Application no: **3/2022/0975**

Address: **17 Clitheroe Road Whalley Lancashire BB7 9AA**

Proposal: **Variation of Condition 2 (Plans) to retain garage and build a smaller extension and remove Condition 6 (Drainage) of planning application 3/2013/0584.**

The Local Highway Authority have viewed the plans and highway related documents and have the following comments to make:

ground floor plan

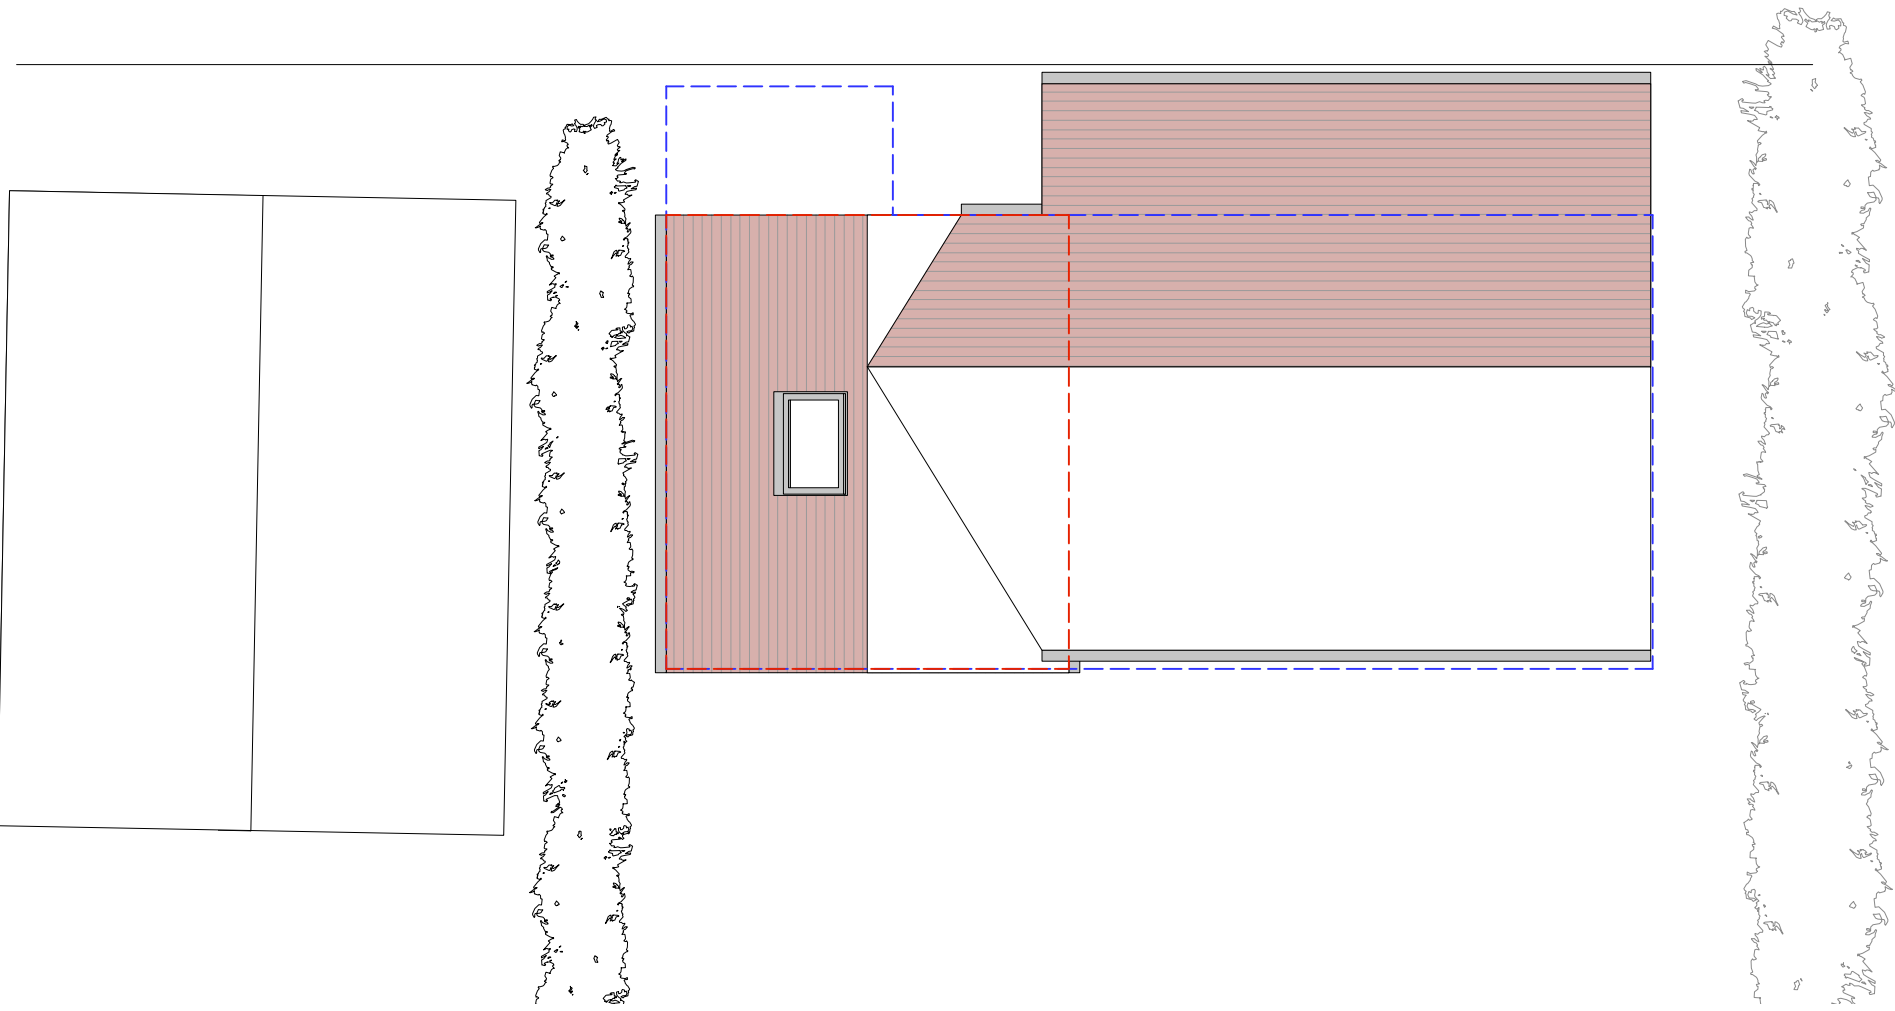
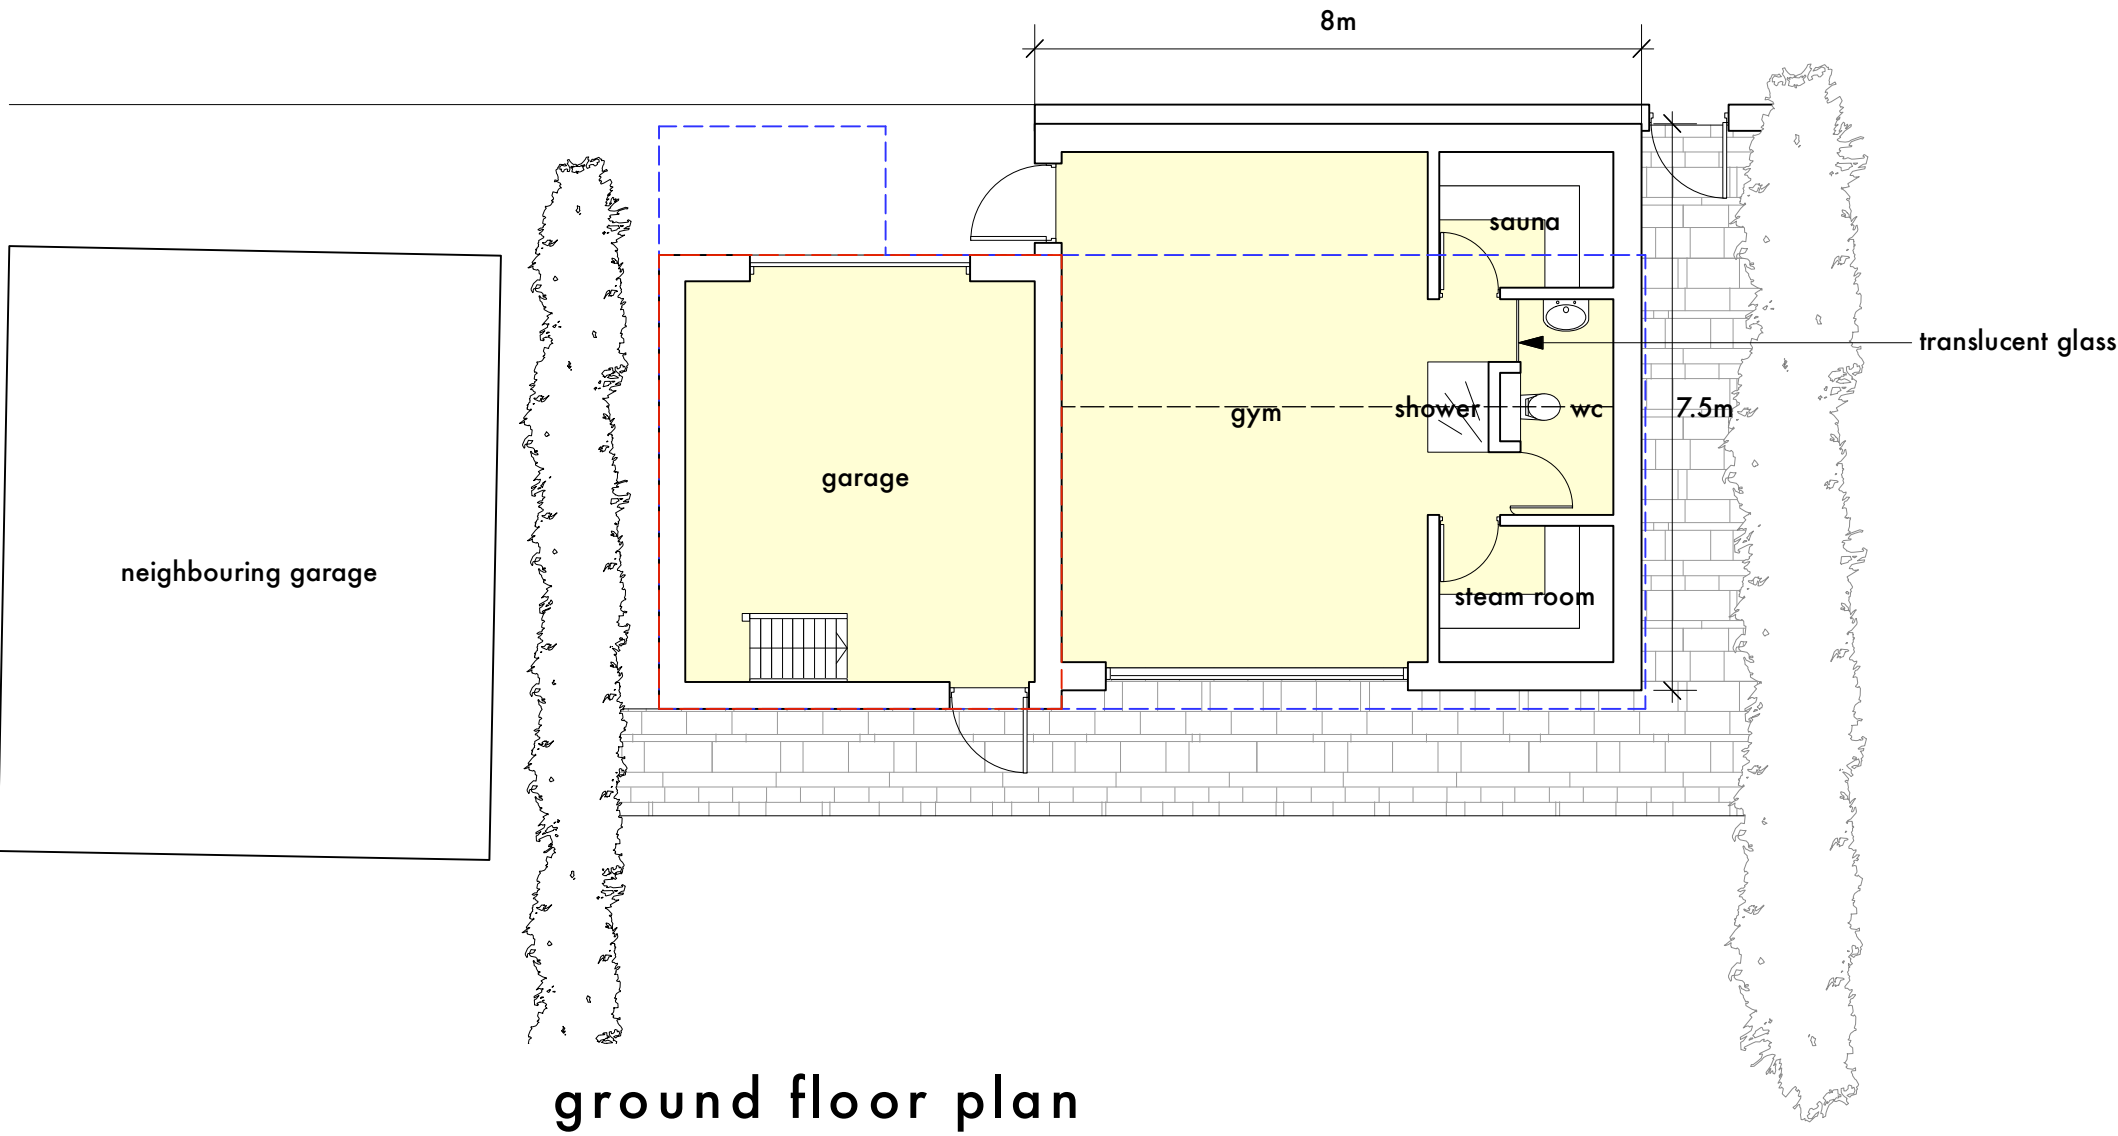
The LHA have reviewed the amended plans and are aware that the Applicant does not want to demolish the existing garage but wants to instead extend it. The LHA have reviewed the plan and have no objection to the variation of condition.

drawing number
D.01

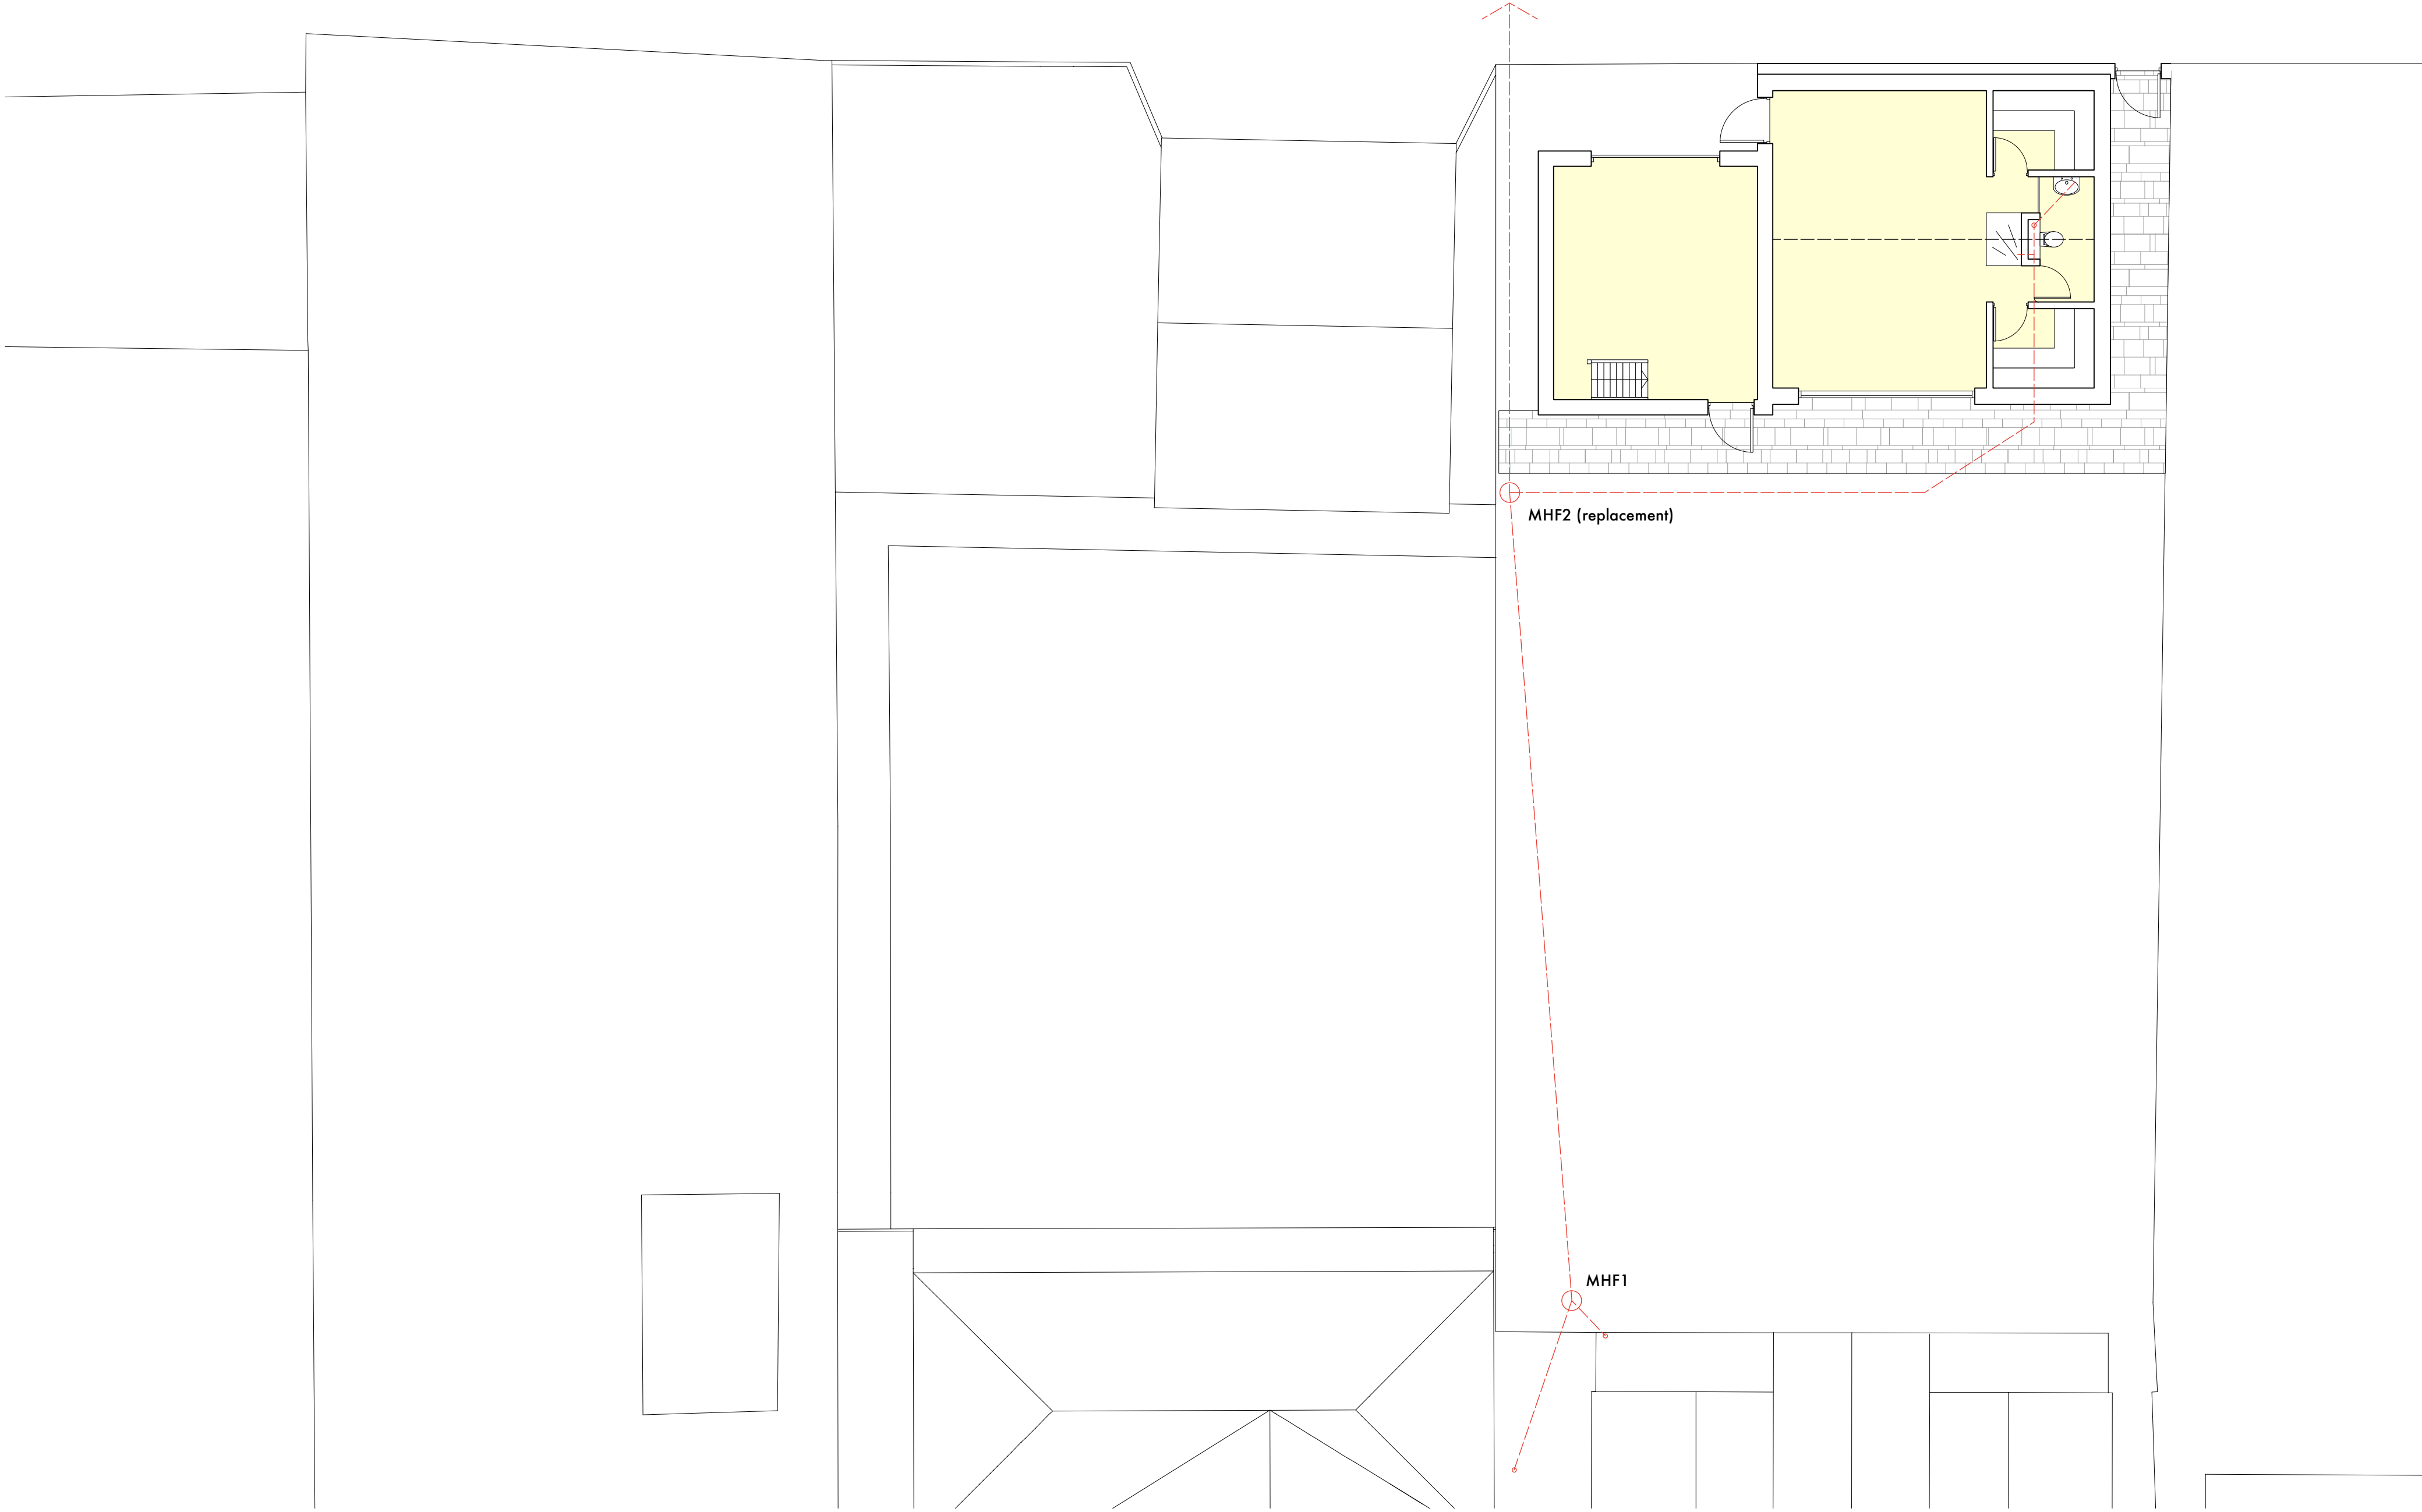
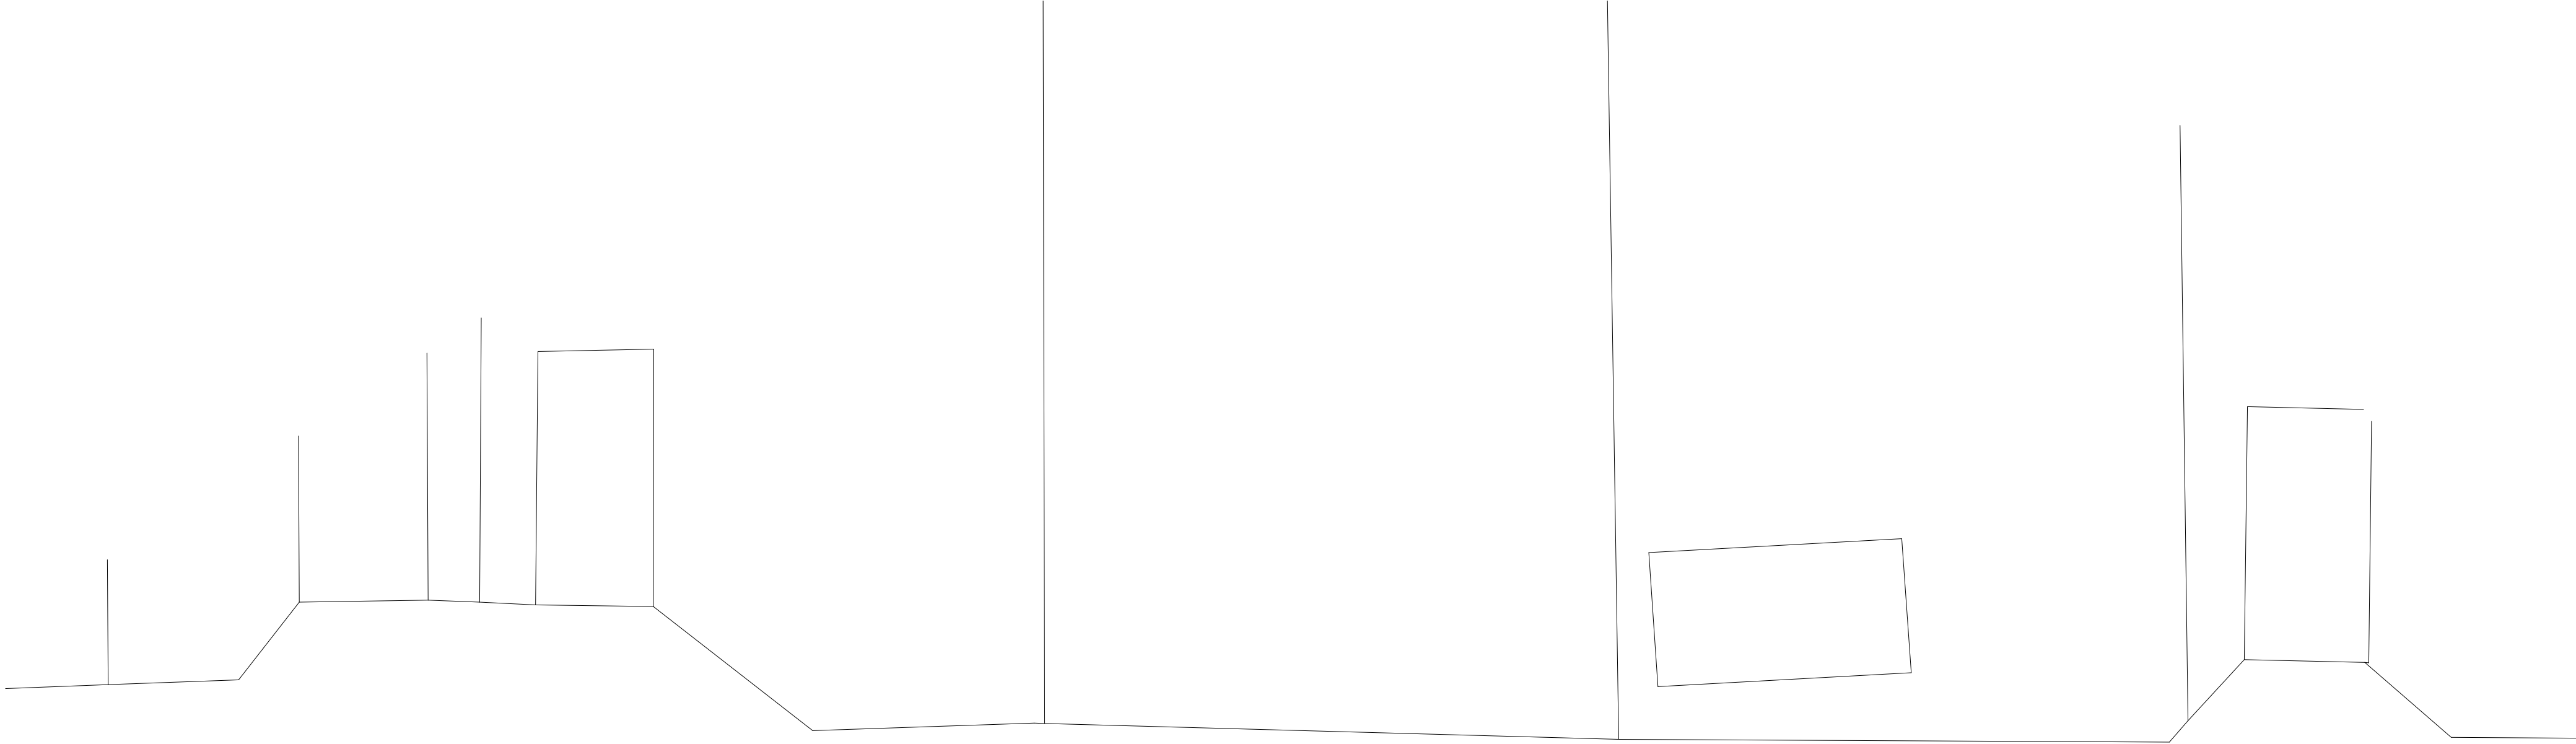
The LHA have reviewed the drainage strategy for the proposal and have no comments to make, with none of the drains from the proposal connecting to a highway gully or drain.
